CITY OF PORTLAND

BUILDING PERMIT

Job ID: 2012-08-4826-MF 3

has permission to Build a 20'x25' detached garage on slab, 1 story
provided that the person or persons, firm or corporation accepting this permit shall comply with all of the provisions of the Statues of Maine and of the Ordinances of the City of Portland regulating the construction, maintenance and use of the buildings and structures, and of the application on file in the department.

Foundation/Slab plan

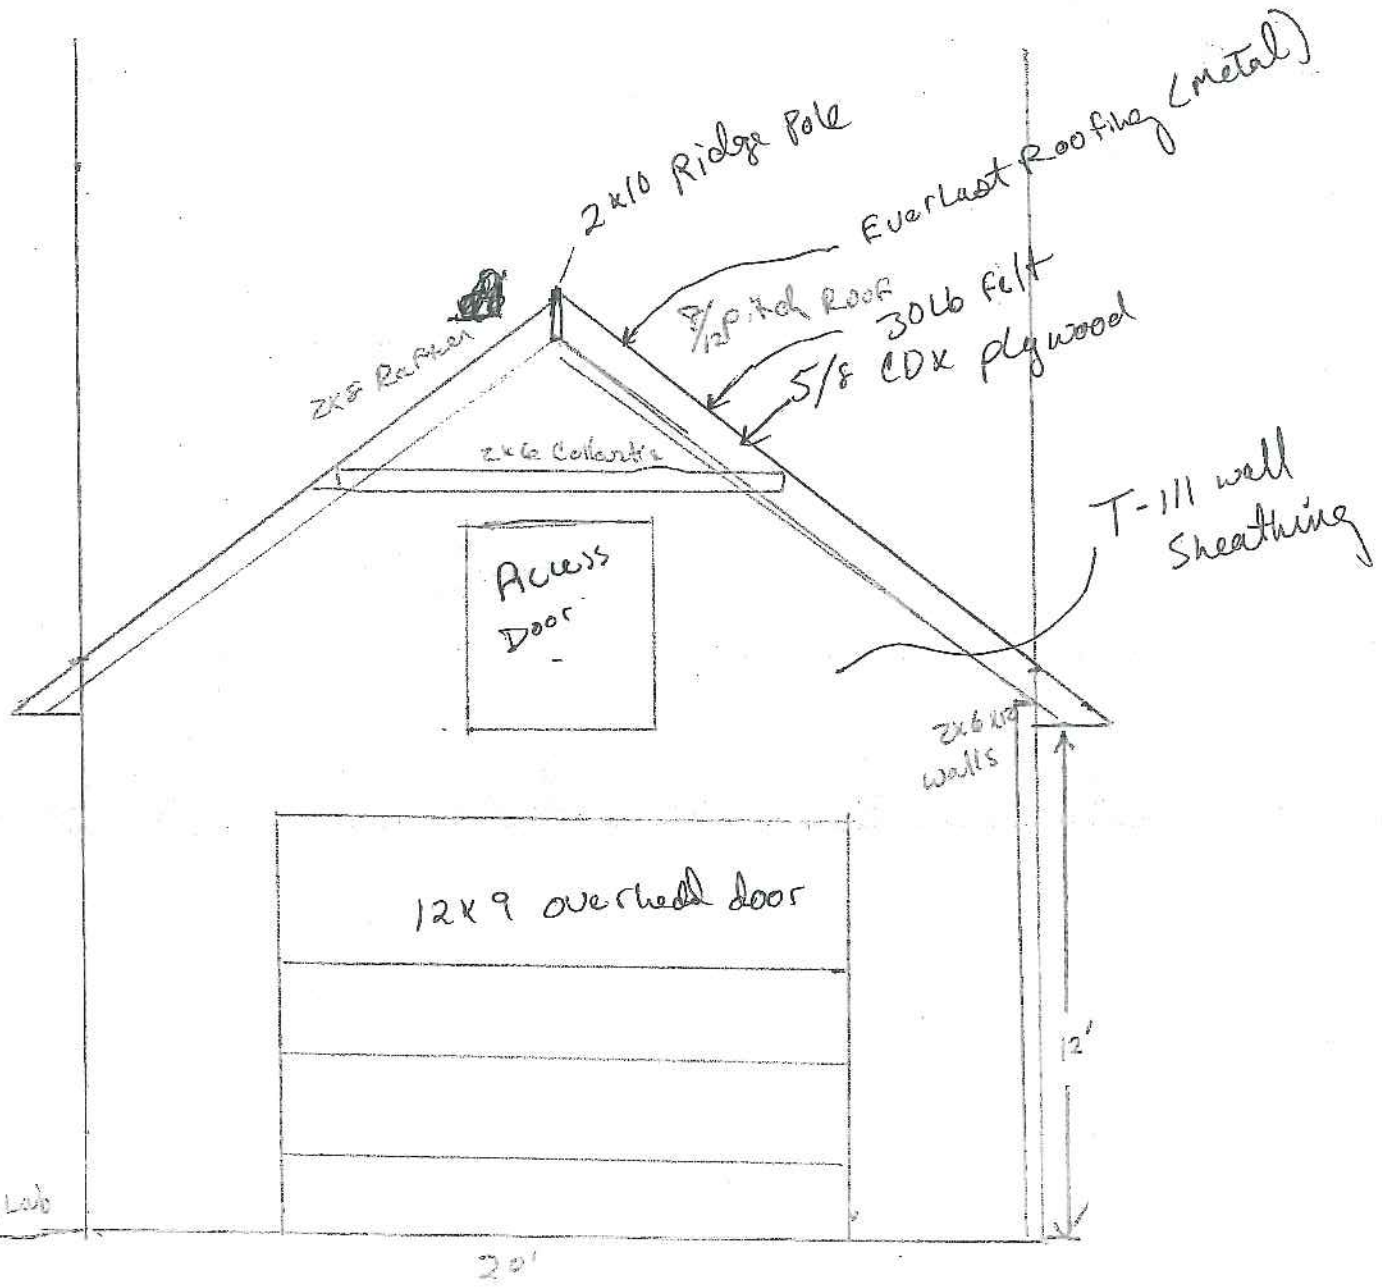
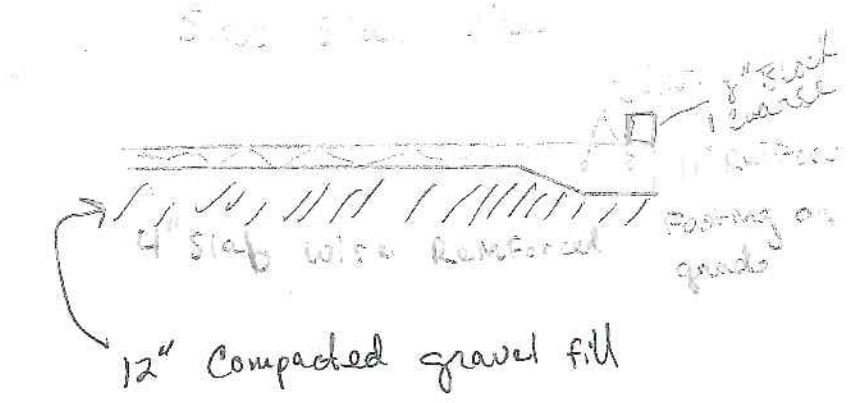
- Braced wall panels are required per the APA recommendations for portal frame bracing without hold down devices, attachment included
 - A minimum 1/2" J-bolt anchors shall be installed 6' OC, 12" from ends through the CMU perimeter block, and the slab will be anchored to the filled block with rebar at the same frequency

Framing Plan

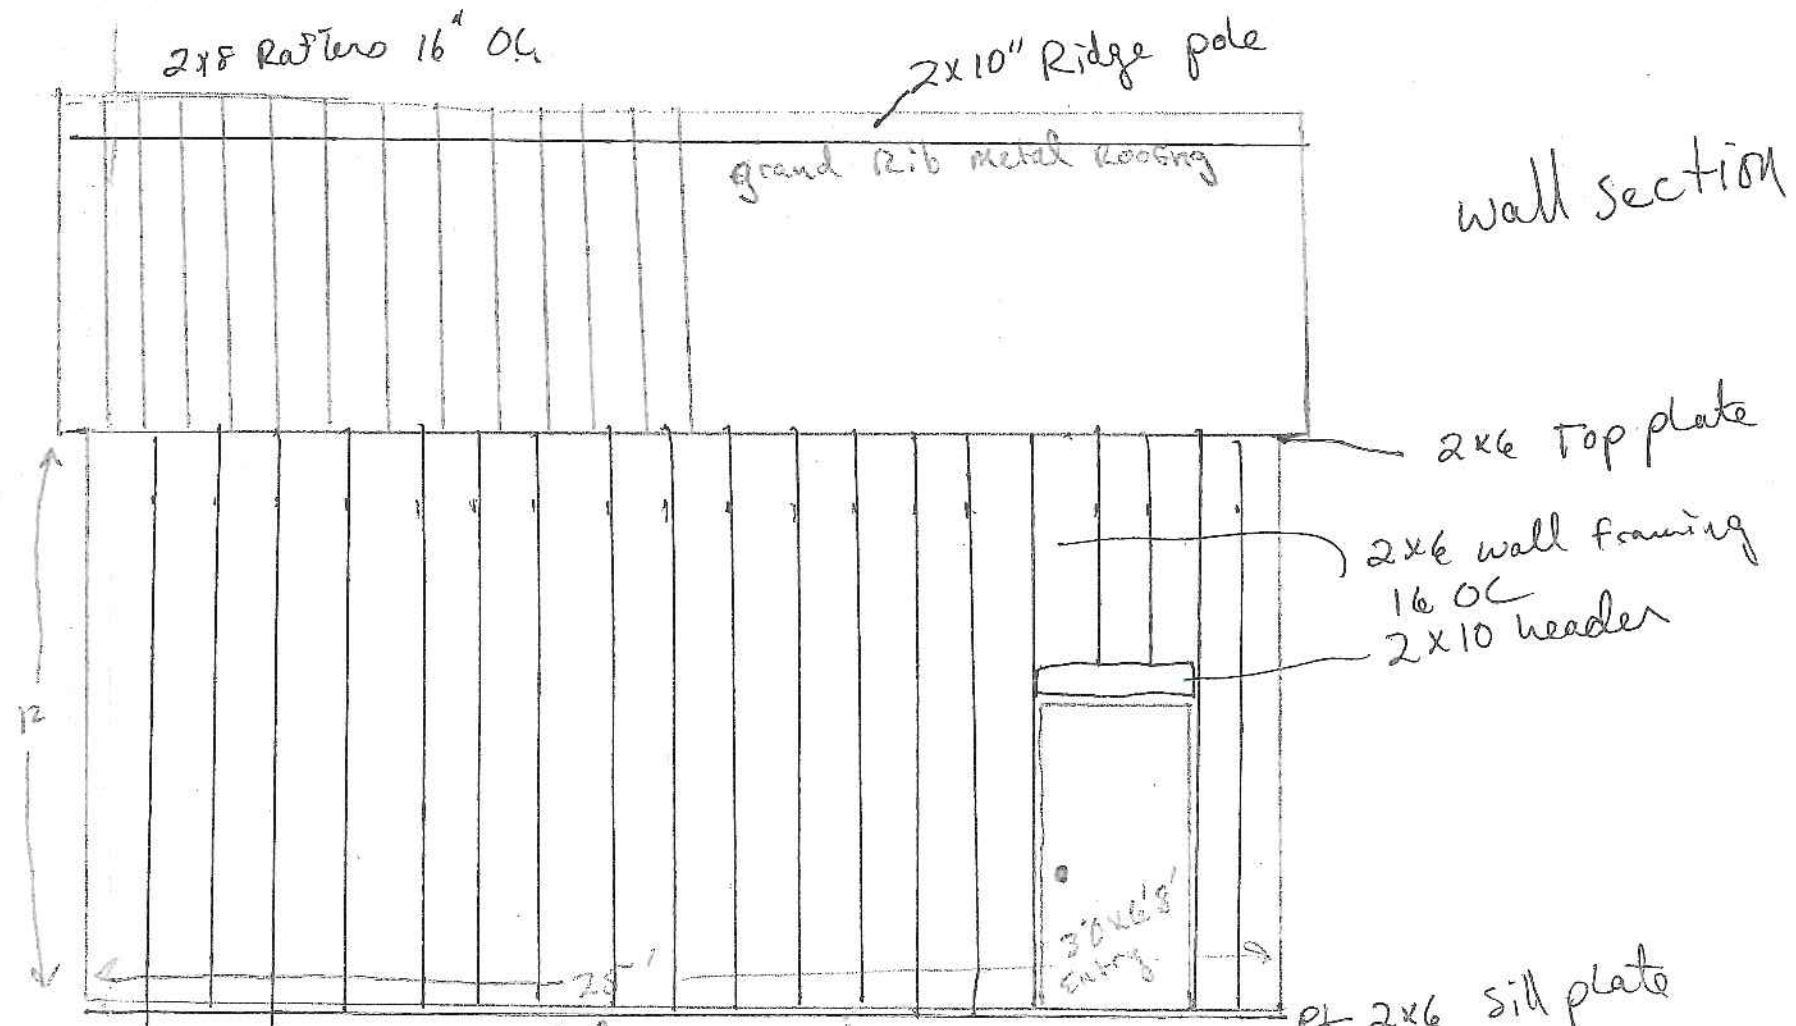
- Eave height on a slab is a maximum of 10', showing 12', will be corrected
 - Garage door header will be a minimum of 2-2x12
 - There are no ceiling joists at this time, the rafter ties are required in the lower 1/4 of the attic with 2x8 rafters
